PLANNING BOARD REPORT PORTLAND, MAINE

Hotel Redevelopment
1210 Brighton Avenue
Level III Site Plan Review
2014-220
Portland Hotels, Inc., Applicant

Submitted to: Portland Planning Board Public Hearing Date: April 14, 2015 (<i>tabled from March 24, 2015</i>)	Prepared by: Nell Donaldson, Planner Date: April 8, 2015 CBL: 265-A-001
--	---

Sheet Title:  
**Post Development  
Drainage Plan**

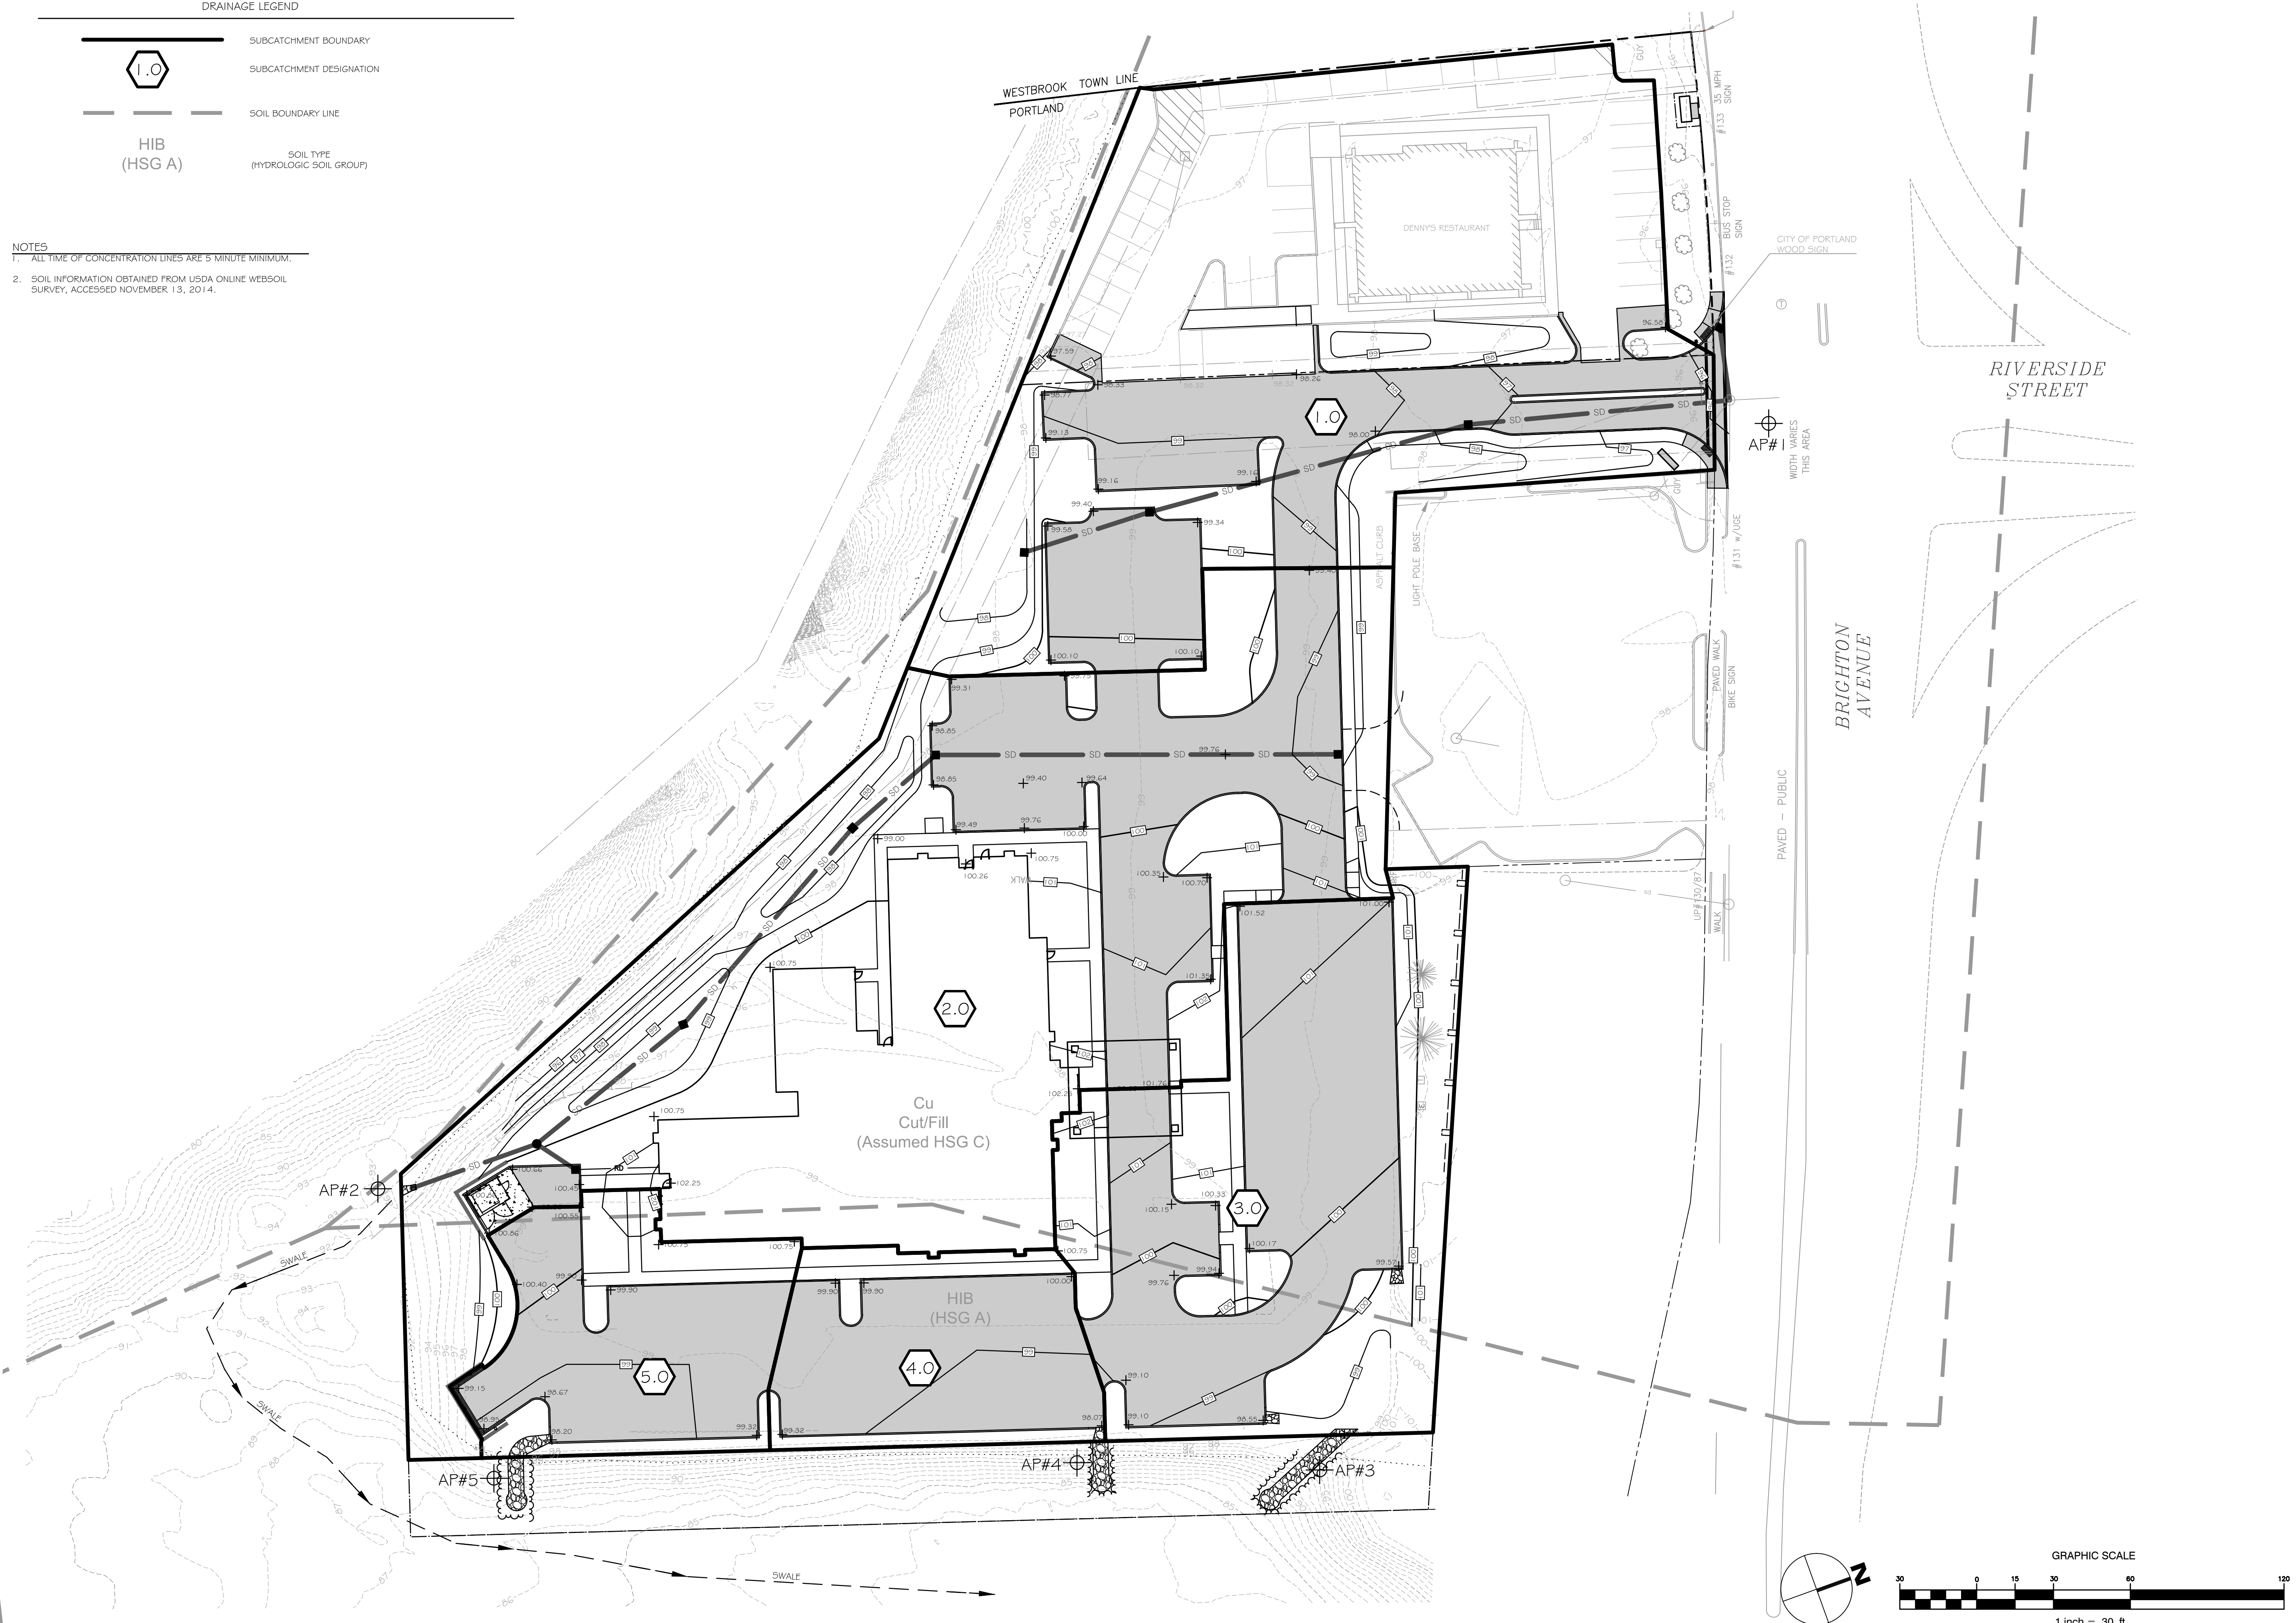
A stormwater outfall proposed on the southern portion of the site (AP#2 on sheet D2.0) discharges to an existing swale within a CMP easement. The Applicant proposes a riprap apron at the pipe outlet. We recommend that the Site Plan approval include a condition requiring that the Applicant's engineer inspect the stormwater outfall AP#2 on Sheet D2.0 and provide a written description and photographs of this outlet, along with any additional proposed stabilization measures as determined necessary for review and approval by the City. Walsh Engineering Associates has stated that they will assess and document the condition of the outfall location once the snow has melted and will provide design details to the city for any additional required stabilization measures.

4. The applicant shall provide documentation, in both written and photographic form, of the condition of the stormwater outfall labeled AP#2 on Sheet D2.0 and provide design details for any additional stabilization measures required, to be reviewed and approved by the Department of Public Services;
